**Consultation Response from KC,  
Trees****2023/91280 Bromley Farm Quarry, Barnsley Road, Upper Cumberworth, Huddersfield, HD8 8PD****Extension to previous Bromley Farm Quarry for extraction of clay, shale and incidental coal****Date Responded: 11/08/2023****Responding Officer: D. Atkinson****Responding Ref:**

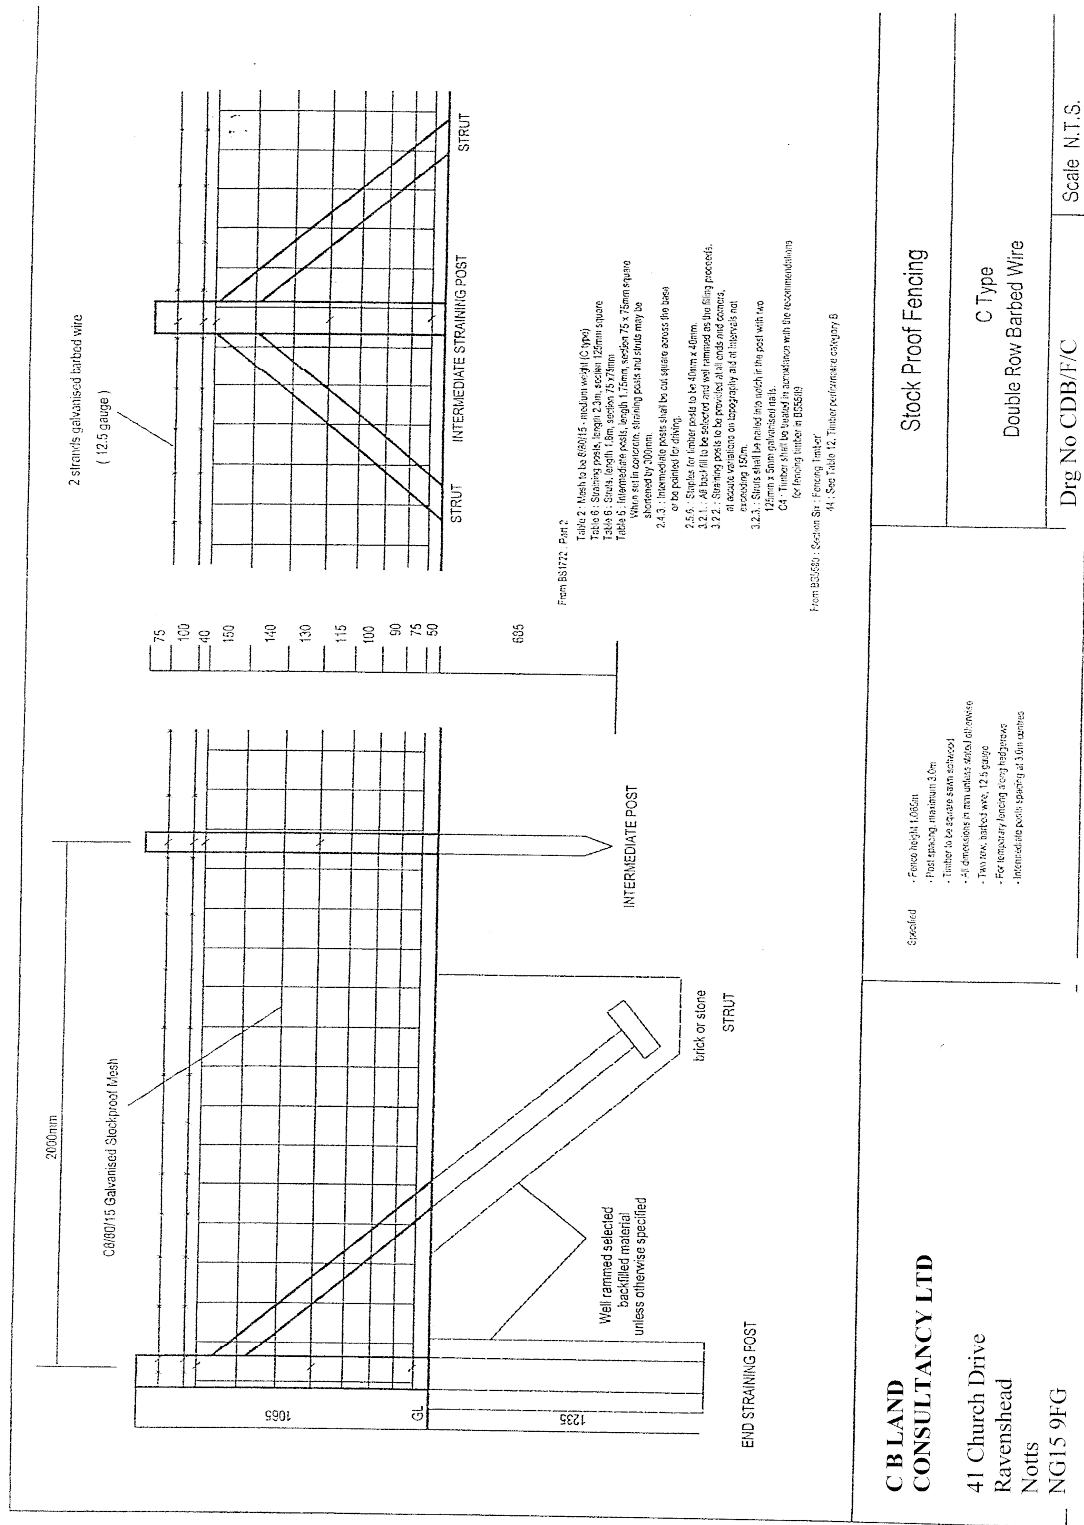
The restoration planting scheme (Drawing reference 22007/510) the plan shows an area of woodland immediately adjacent to the south boundary of the site. Magic Maps also shows a woodland area in that location.

The water treatment area and one of the overburdened mounds could be a threat to the woodland that is directly to the south due to their proximity to the woodland edge and water runoff, running downhill towards/into the woodland.

- Amendments to the Landscape & Visual Impact Assessment
- An assessment of the value of the trees proposed to be removed to facilitate the development.
- Consideration about the site layout to provide better clearance of the woodland adjacent and inclusion of appropriate measures to protect the woodland from run-off soil contamination.
